COUNTY COUNCIL'S RESPONSE TO CONSULTATION ON THE FOLLOWING DEVELOPMENT PROPOSAL

Application No: 17/02534/OUT-2

Proposal: OUTLINE - The construction of a business park of up to 60,000 sq.m (GEA) of flexible Class B1(a) office / Class B1(b) research & development floorspace; parking for up to 2,000 cars; and associated highways, infrastructure and earthworks

Location: Land North Of Bicester Avenue, Garden Centre, Oxford Road, Bicester.

### Proposed Junction Mitigation

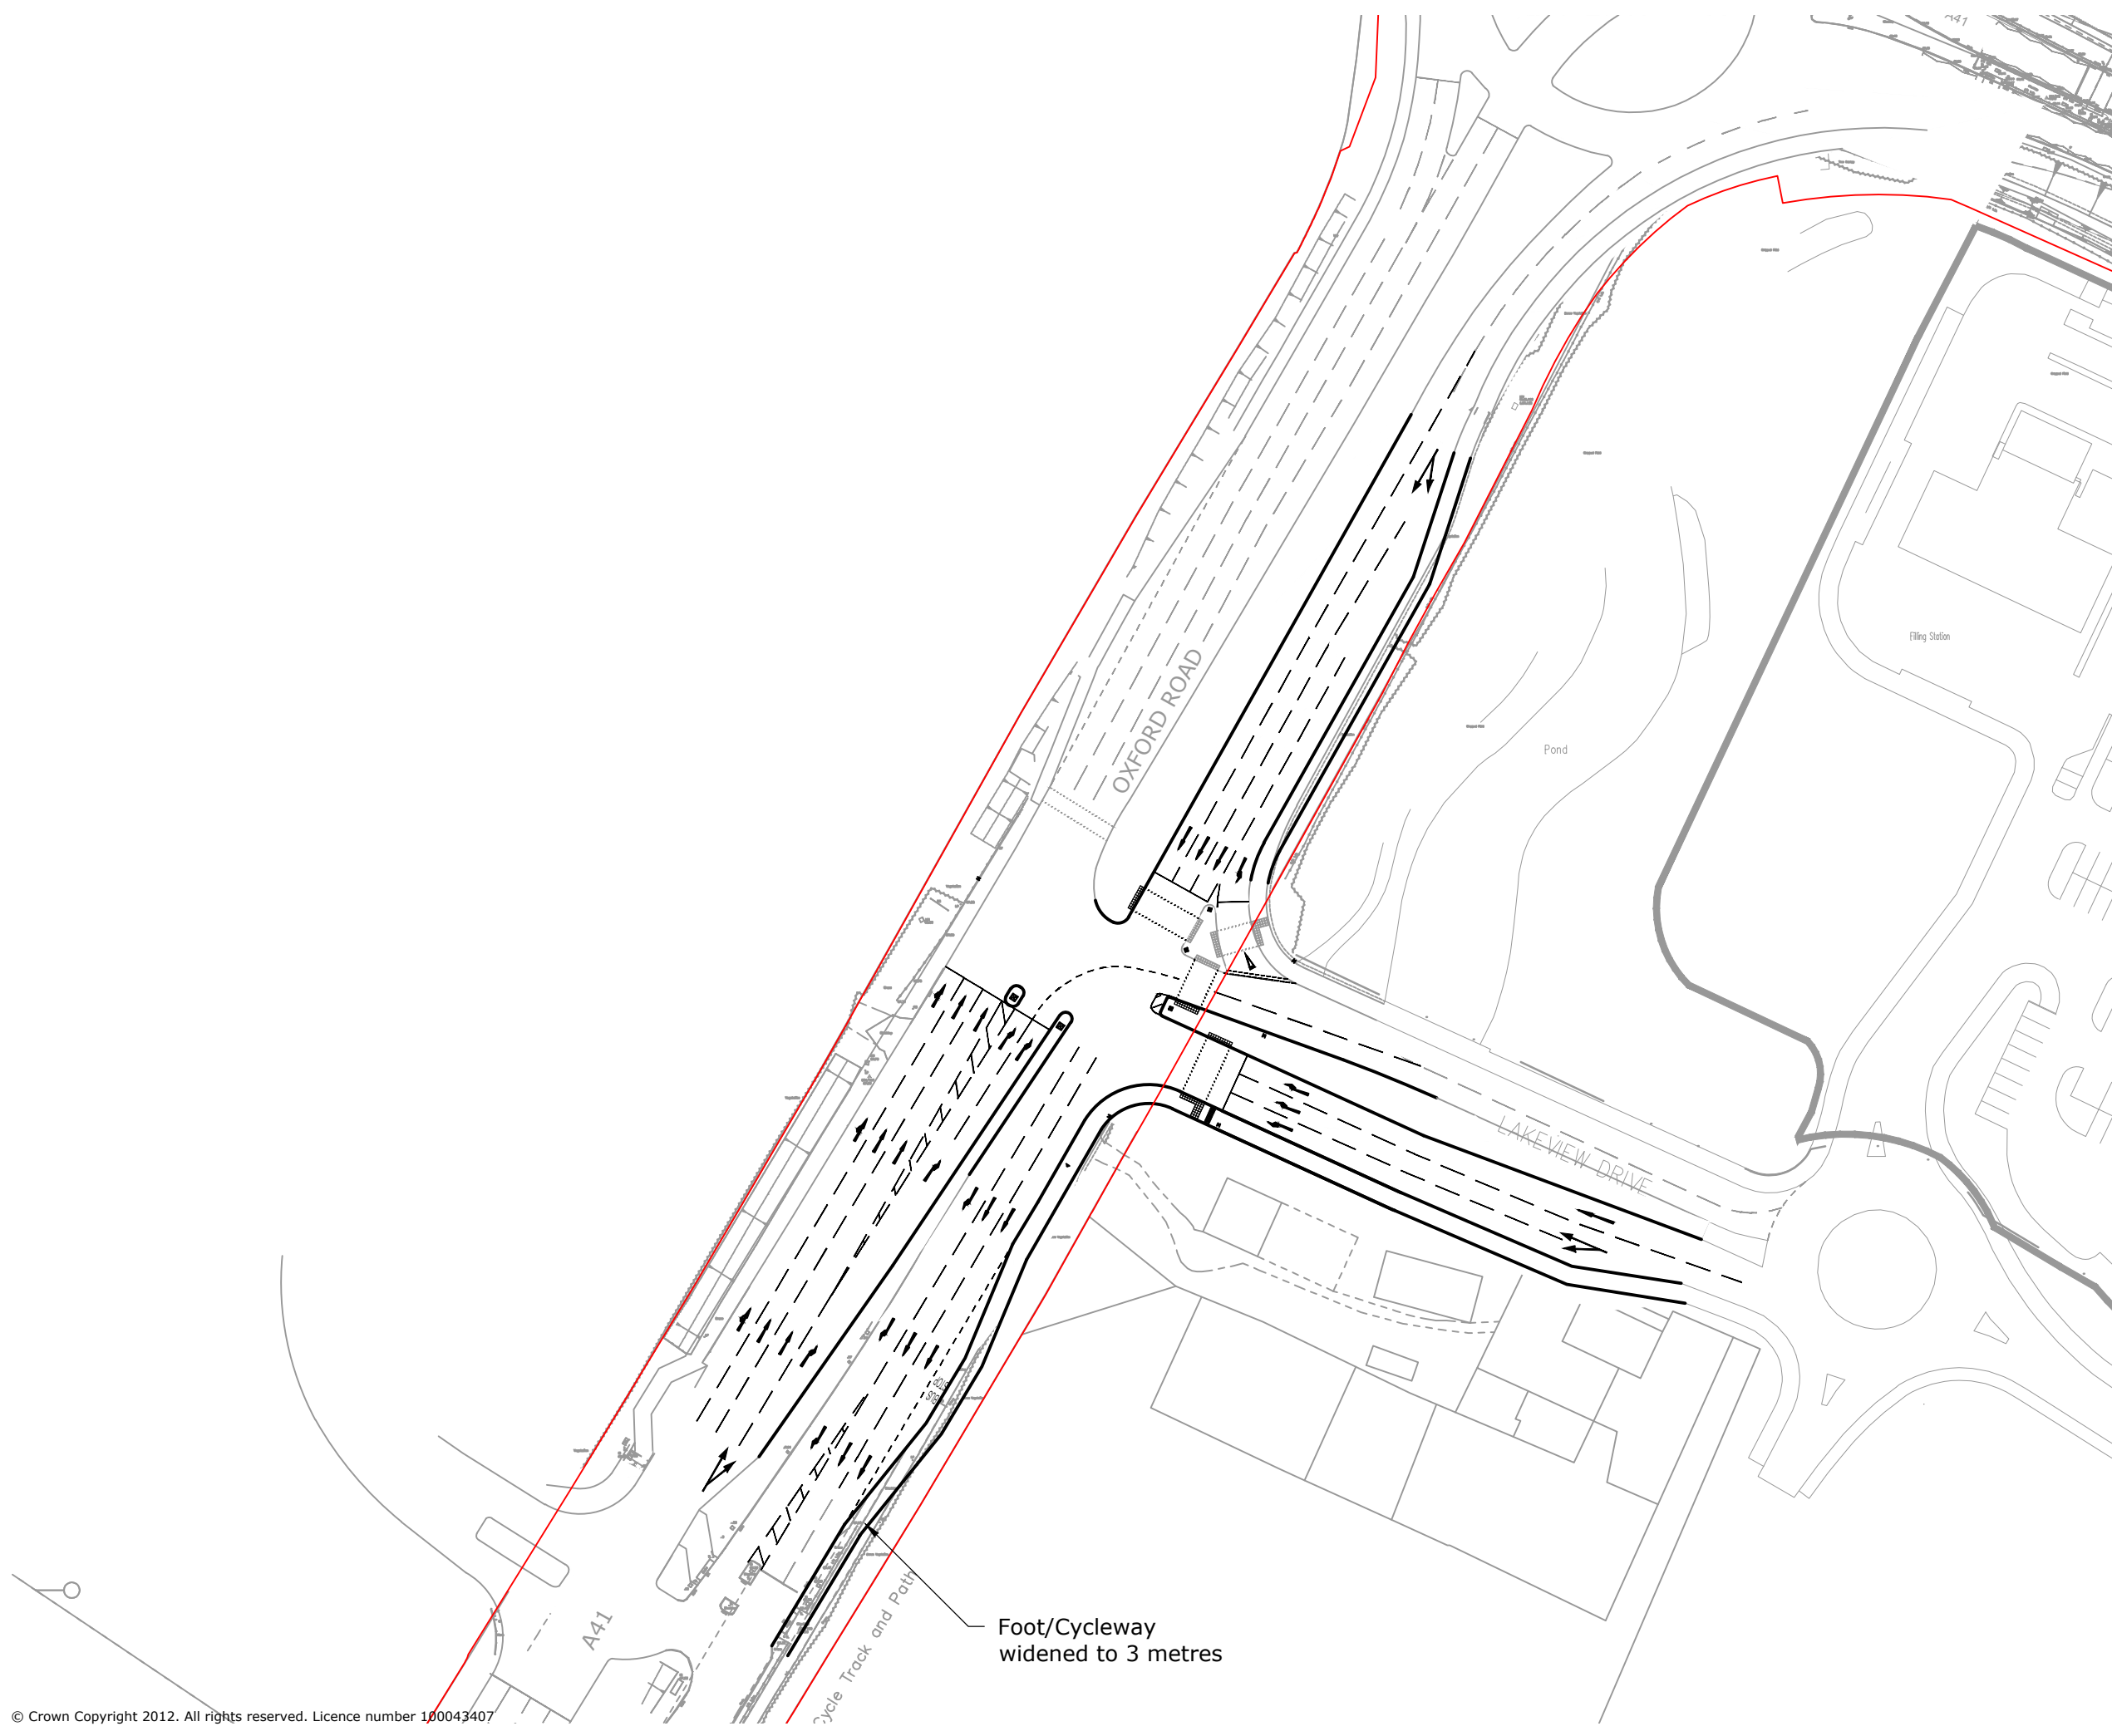
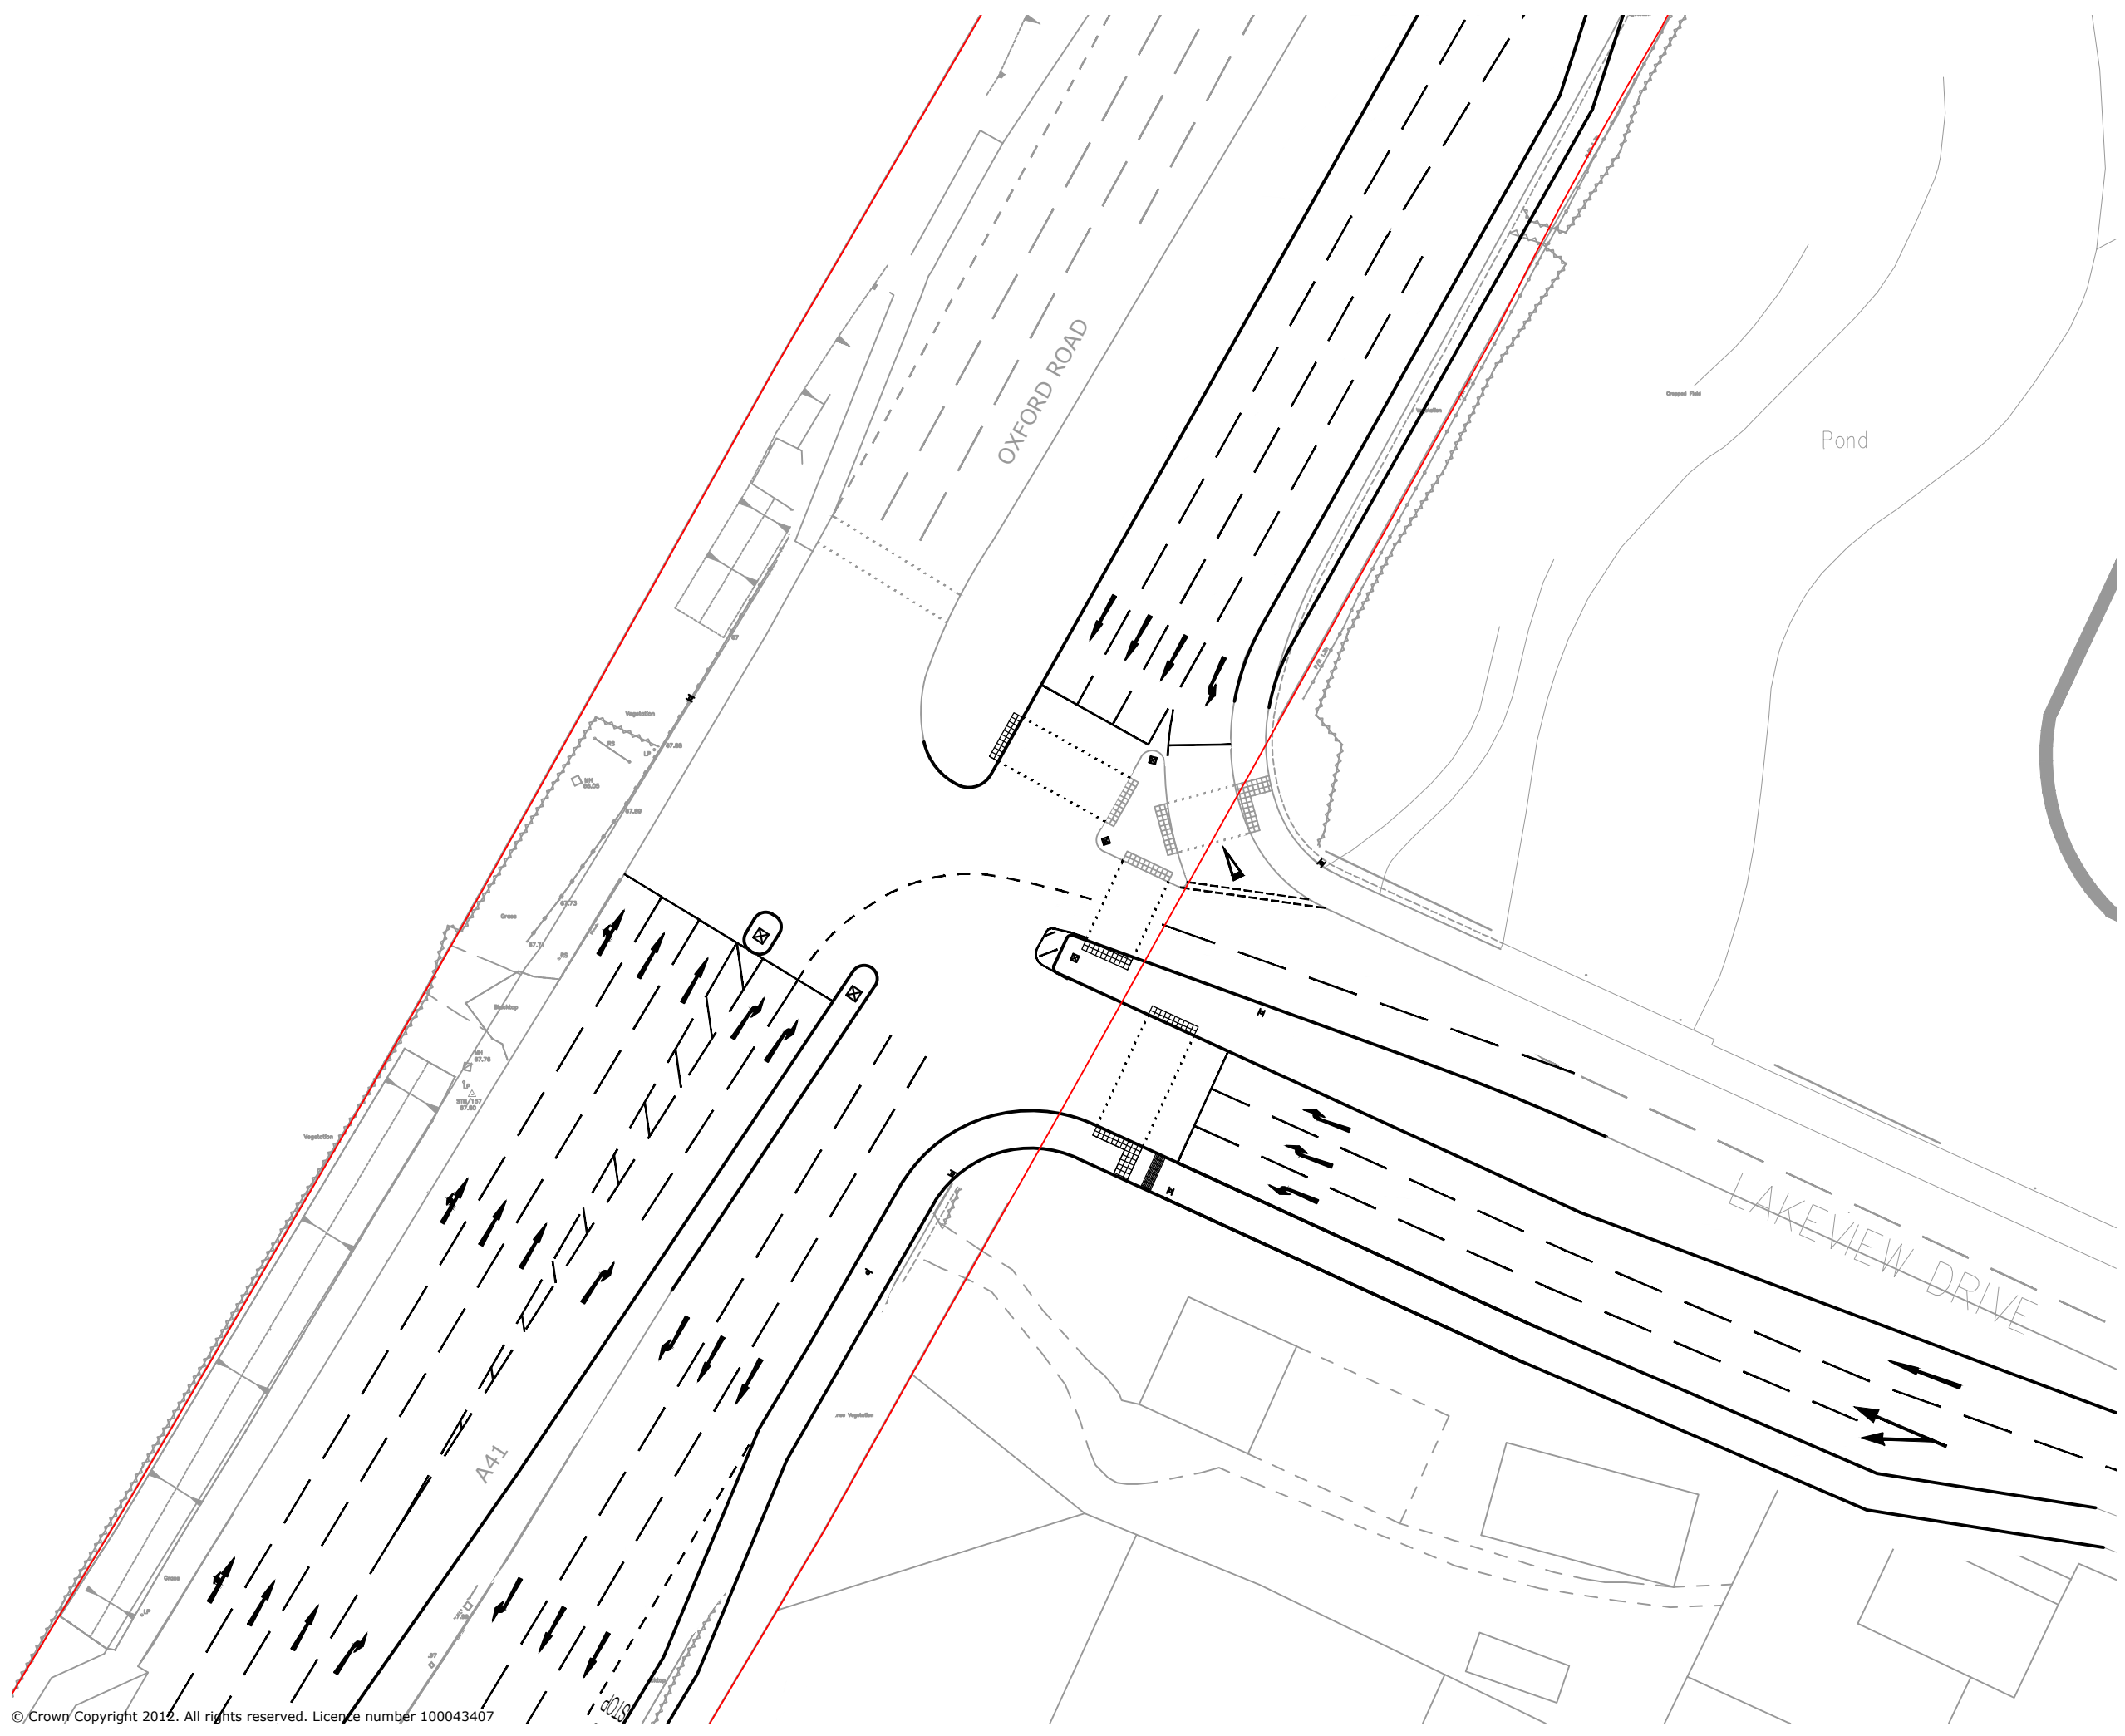
Table 6.3 is a summary of the junction modelling results with 60,000 sqm of office development including proposed mitigation. The 2026 with development and mitigation scenario predicts RFC values of 0.91 on the Kings End arm (AM peak) and 0.90 on Oxford Road (PM peak) which are both well over the theoretical operational thresholds. *Para 6.11* of the TA concludes that the junction shall be expected to operate within theoretical capacity to which I disagree, again pointing out that the LHA follows the accepted practice of treating RFC values over 0.85 as being above theoretical threshold for capacities at roundabouts.

To this extent and in consideration that conventional roundabout modelling was used in place of a mini roundabout I do not agree with *para. 6.12* in the TA that claims betterment on one entry yet operation on other arms is seen to deteriorate.

Analysis from the tables referenced above shows that without mitigation, Oxford Road/Lakeview Drive junction is predicted to deteriorate significantly. The Practical Reserve Capacity is shown to plunge into a more negative value indicating that the junction shall typically be suffering from traffic congestion, with queues of vehicles beginning to form. Degree of Saturation (DoS) values on certain arms particularly Oxford Road are observed to be significantly over the theoretical capacity.

Whereas the proposed mitigations appear to present a degree of improvement on the entire junction (as illustrated in *Table 6.6*), Oxford Road/Lakeview Drive junction is predicted to suffer more in the “Do-Something” scenario than the “Do-Nothing”. In the Do-Nothing scenario, the junction is forecast to operate with a DoS of 70.4% and 85.8% in the AM and PM peak hours respectively in 2026. With the development, including the proposed mitigation this rises to 92.9% and 97.7% in the AM and PM peaks respectively. It is without question that the development shall have a detrimental impact on the existing network which has not been adequately mitigated.

The proposed mitigations do not bring the junction operation to a level that LHA sees adequate. The TA suggests that a Degree of Saturation of up to 100% is acceptable, but the Highway Authority does not accept this, and maintains that the threshold of acceptability should be 90%.

I am very concerned about the predicted queues on certain arms of the junction. The modelling exercise (*Table 6.6*) shows queues on Lakeview Drive reaching 42 vehicles from the junction. Lakeview Drive's distance (90 metres) from the junction to the roundabout with Tesco should be borne in mind when looking at queues of 42 vehicles. Taking a conservative approach that a queueing vehicle takes up to 6 metres, this Lakeview Drive section would accommodate only 15 vehicles before traffic backs up to the Tesco roundabout, effectively stopping any further vehicles from egressing.

With vehicles unable to exit Tesco it is likely that traffic within the site would back up to the extent that vehicles would not be able to get in, with the risk that queueing traffic would back up onto the A41.

Although *para 6.25* of the TA highlights that Lakeview Drive is privately owned and therefore queueing would be accommodated off the public highway, this section of road is shared by Tesco and the consented McDonalds restaurant. It is my opinion that it would be in public's interest that movement of traffic on Lakeview Drive is not disrupted. Very substantial delays could also be detrimental to road safety as they may well lead to unsafe manoeuvres by impatient drivers.
